From: Anita Gardner
Sent: 16 May 2018 11:09
To: Karen Parsons
Subject: FW: A/8/18/PL Land Rear of 1 To 6 The Cottrells, Angmering

From: Anita Gardner [<mailto:Anita.Gardner@arun.gov.uk>]
Sent: Wednesday, May 9, 2018 12:38 PM
To: [REDACTED]
Subject: A/8/18/PL Land Rear of 1 To 6 The Cottrells, Angmering

A		Layout amended		10.11.17	
Rev		Description		Date	
Job Reference		Client			
New House The Cottrells Angmering, BN16 4AF		AM Homes Ltd			
Drawing Title		Drawing No		Rev	
Ground Floor Plan		ADC962/04		A	
Date	Scale	Dwg Size	Plot Style	Drawn	Checked
24.04.17	1:100	A3	ADC-red	TGS	AD

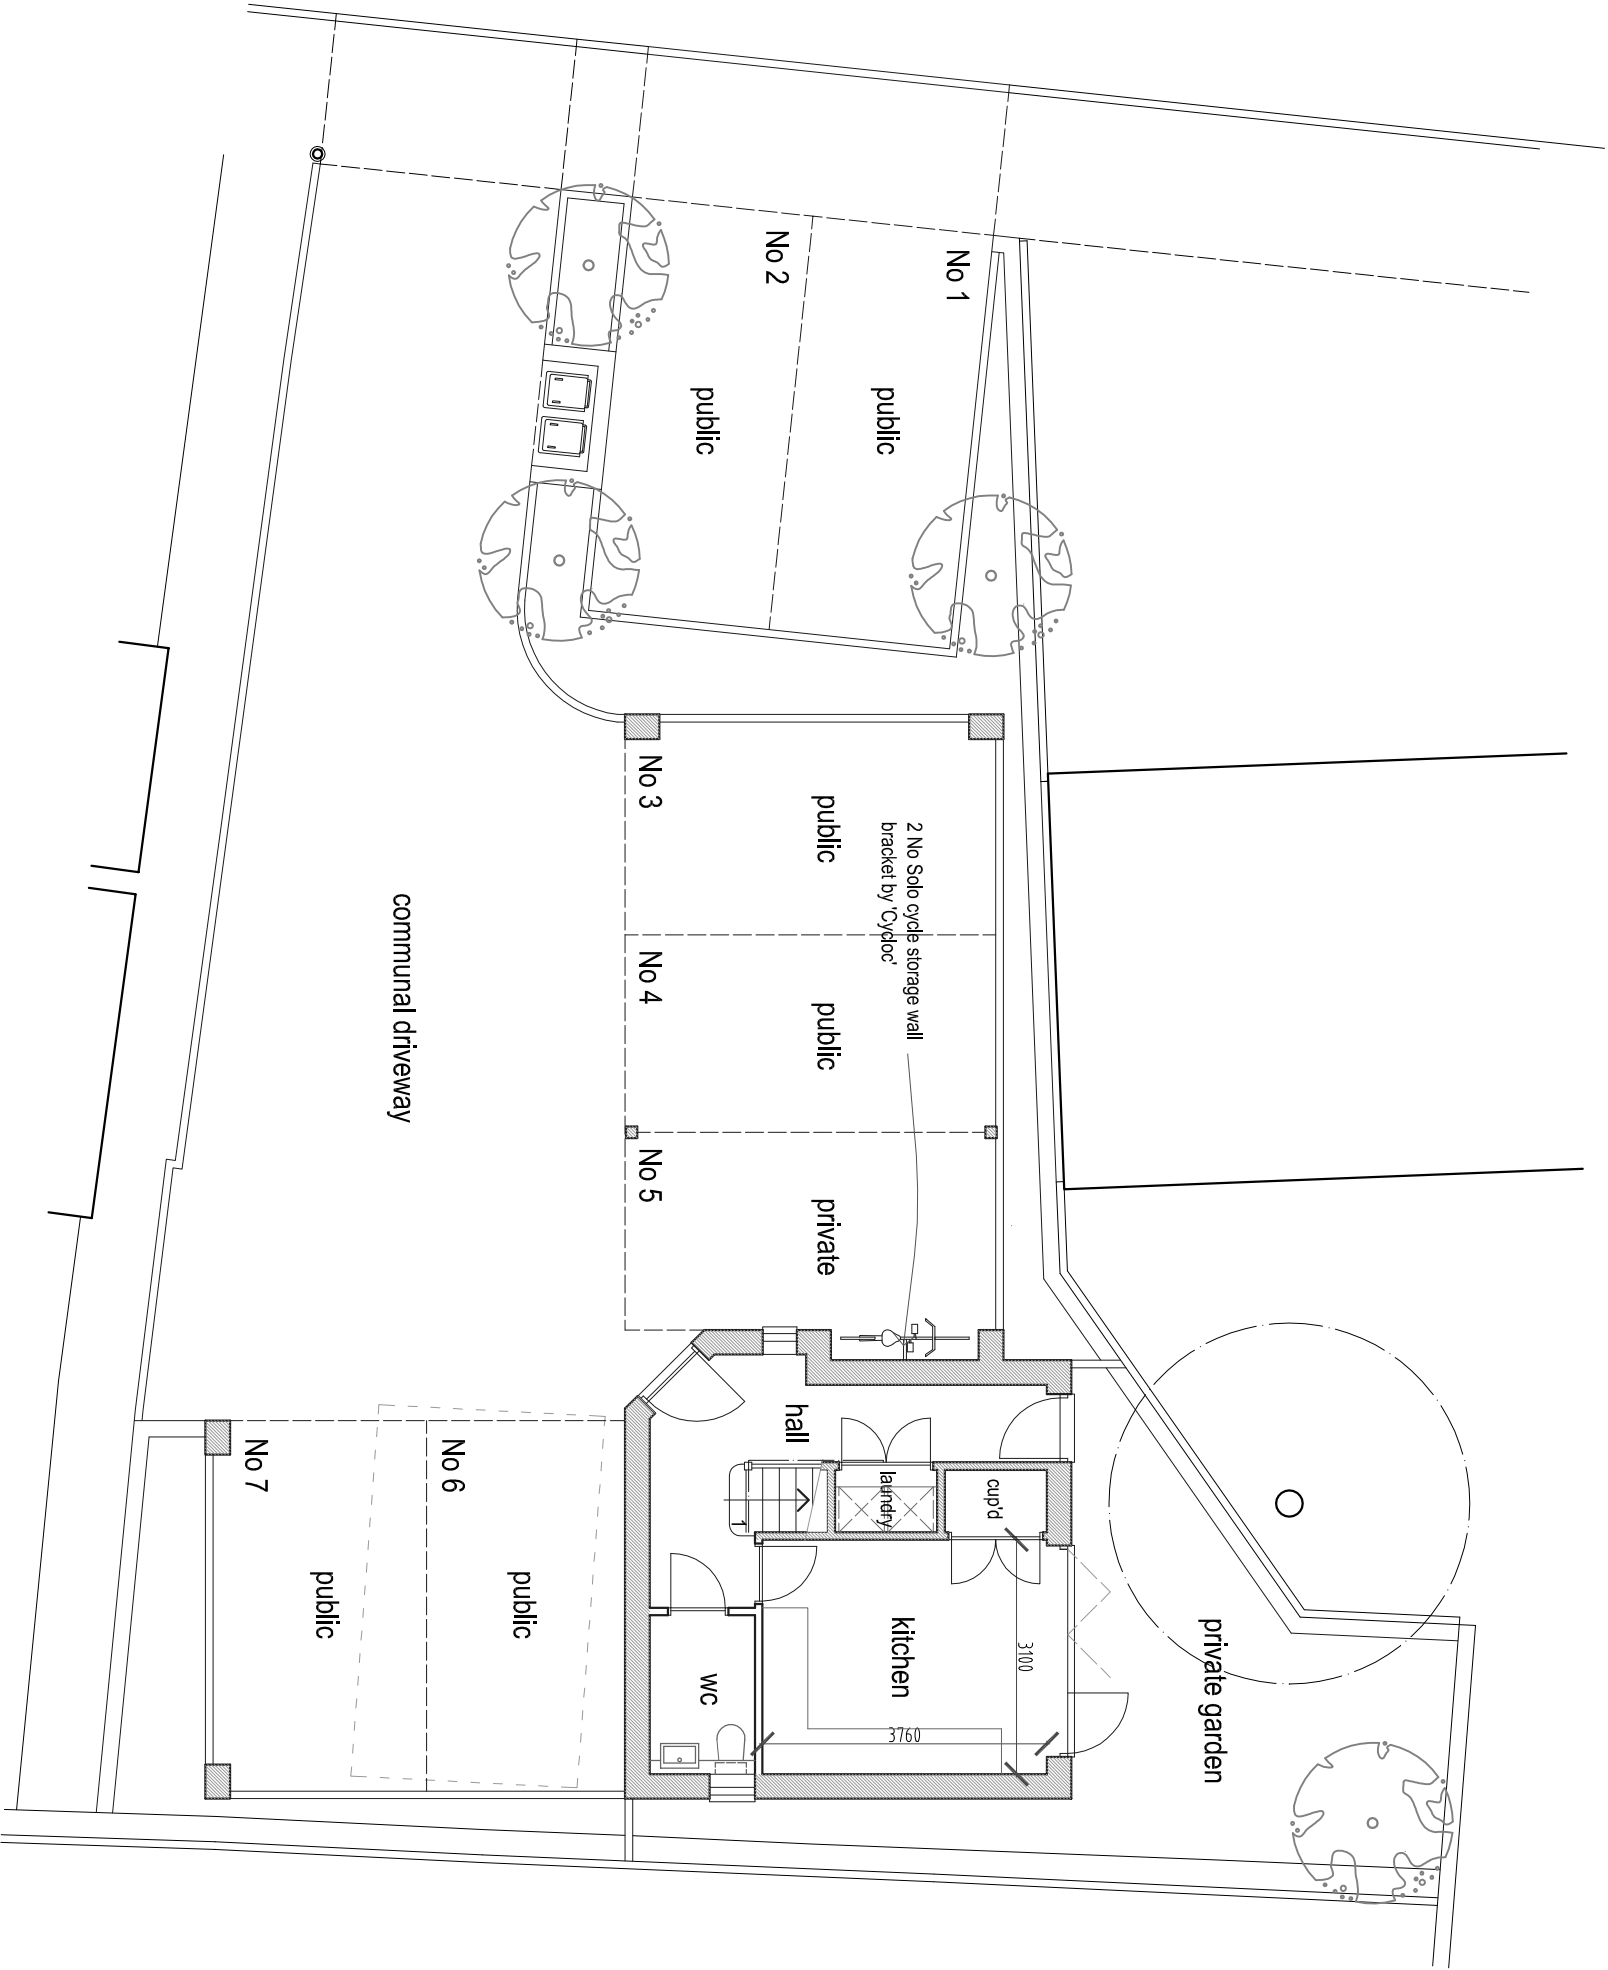
The above application has been withdrawn from today's committee meeting since it has become apparent that the application description does not reflect all of the changes included in the application which is misleading. The size of the dwelling has increased from that approved under A/173/16/PL. The description of the application will be altered to add reference to the slightly amended internal floor layout and the increased footprint of the dwelling. The application will need to be re-advertised. If you can agree to extend the time on the application until 22-06-2018 to allow time for this to take place I will pass the application through for processing alternatively the application is likely to be refused under delegated powers.

I have double checked the site dimensions and I can confirm my application drawings No ADC 962/04A, 13A & 14A are correct as built and do not need amending to reflect what has been built. I have overlaid these with the Planning Permission A/173/16/PL plan MP-01 01C - see attached drawing ADC 962/18 which shows the approved building outline in red. The footprint is generally in line with the approved scheme but there are small discrepancies because the unfortunately the foundations had to be piled and piling is not always an exact science.

Rev	Description	Date
Job Reference New House The Cottrells Angmering, BN16 4AF		
Client AM Homes Ltd		
Drawing Title First Floor Plan & Roof Plan		Drawing No ADC962/13
Date 16.01.18	Scale 1:100	Dwg Size A3
		Plot Style ADgrey.spl
		Drawn AD
		Checked AD

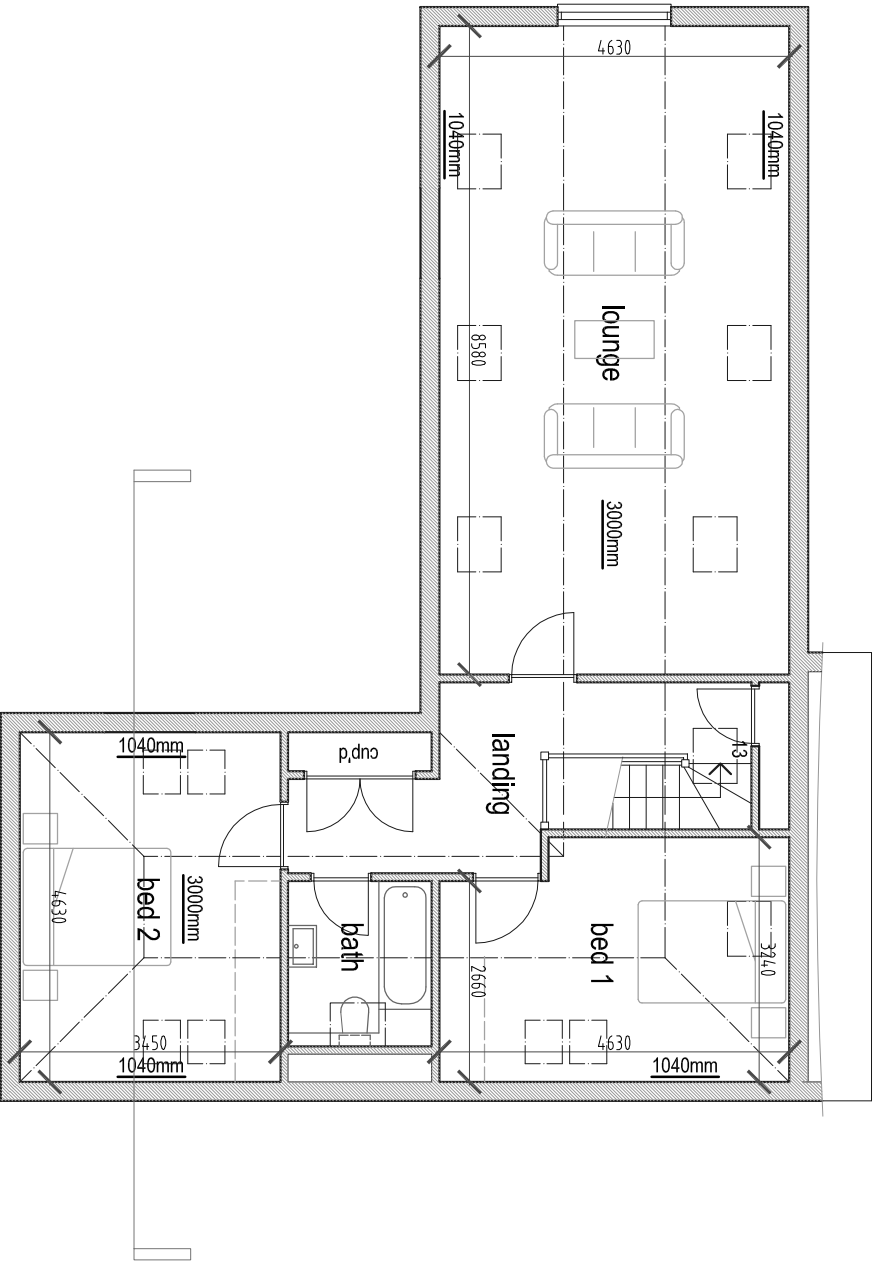
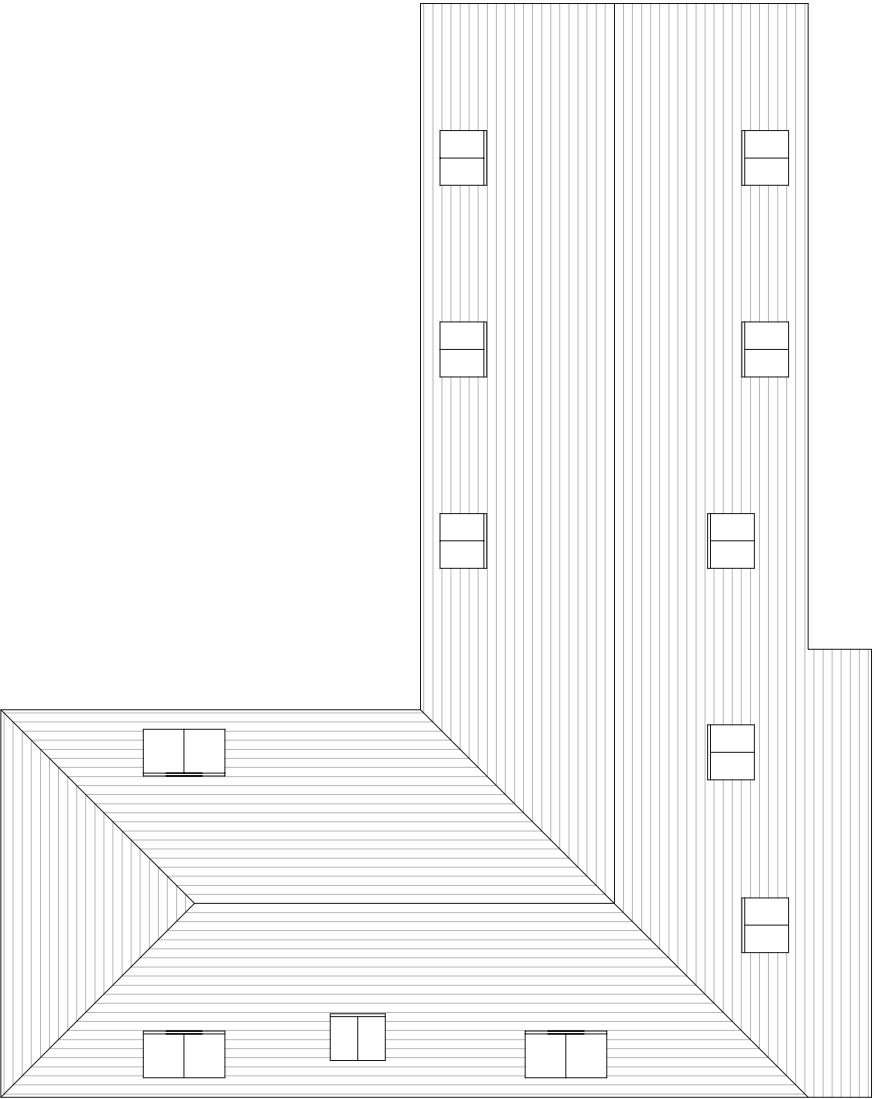
Thank you for the site plan which does assist in outlining the differences and will now be processed accordingly. However I still require receipt of a substitute scaled 1:100 First Floor Plan with corresponding dimensions written on it. The submitted drawing ADC962/13 does not scale to correlate with the first floor as now submitted. The longer sides of the building scale at 14.4m and 10.8m so this will need amendment. I also request that the west and east elevation plans are checked against this submitted plan.

If that is the case you will need to submit dimensioned scaled first floor and roof plan with the sizes indicated as approved under A/173/16/PL and the application can then be placed on the June DC Committee for consideration.

Drawing Title	Drawing No	Rev
Planning Permission	ADC962/18	
Comparison Plan

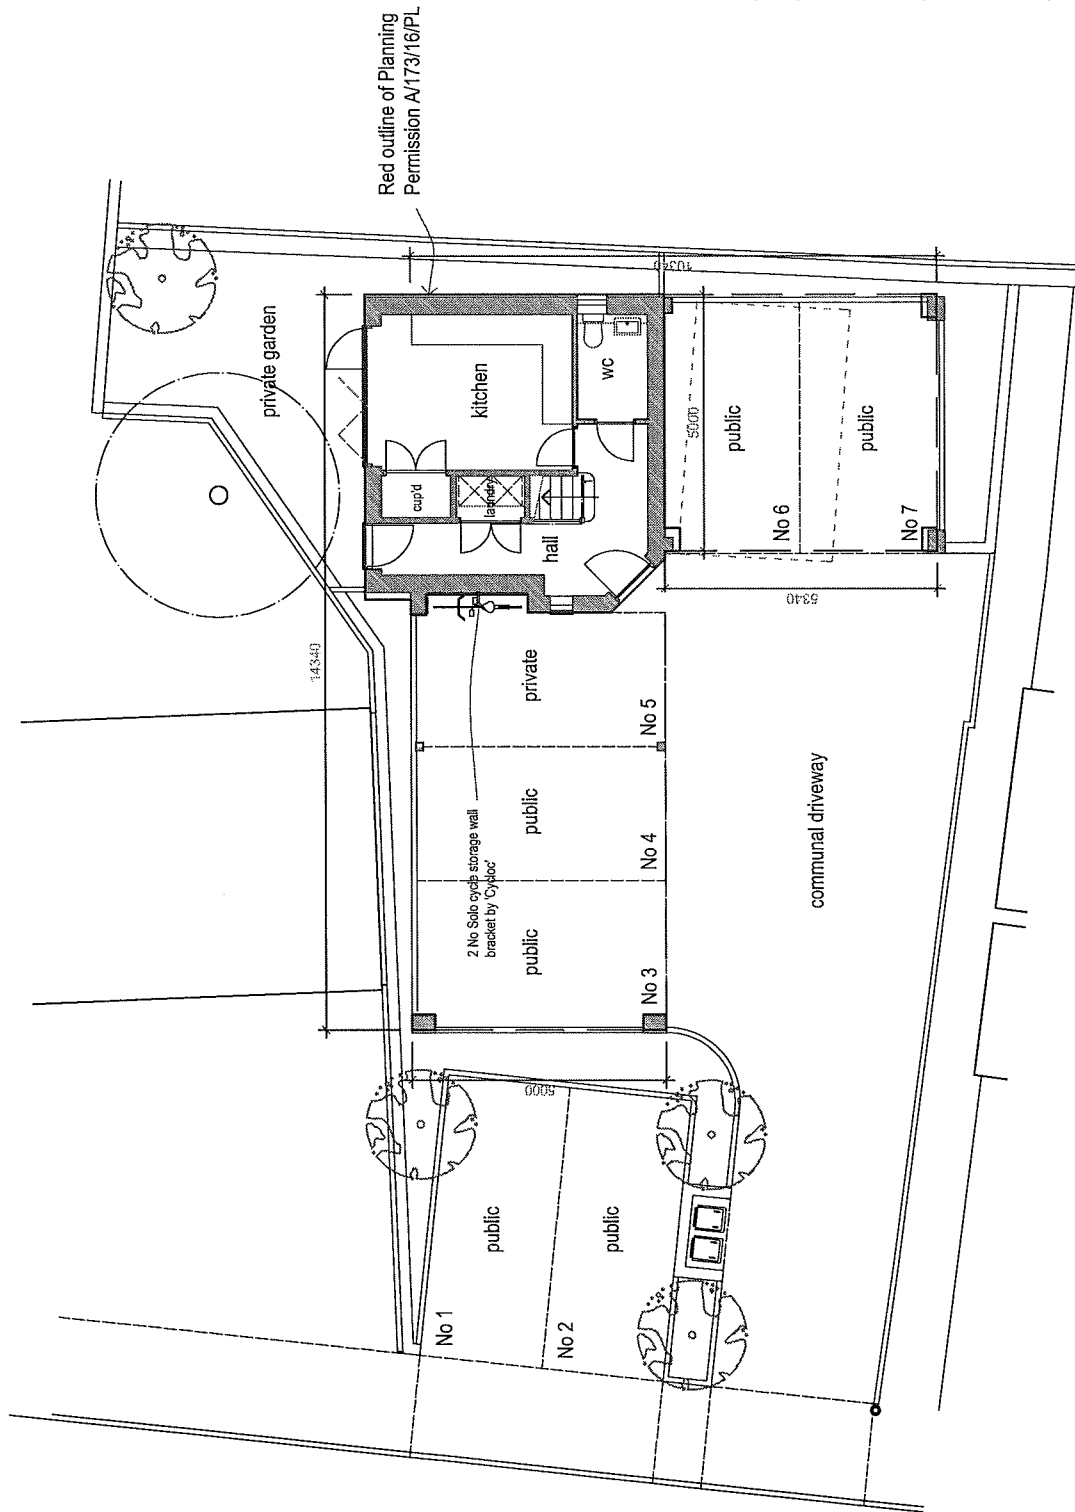
The discrepancy in the plans was referred to in a representation received the morning before Committee and as a consequence was checked and found to be an anomaly. The application could not therefore proceed to the meeting with this ambiguity.

Two of the columns, and therefore the first floor structure, is 150mm closer to the southern boundary. Other than that the building is online, within or smaller than the footprint of the approved scheme. Let me know if you need any additional information.
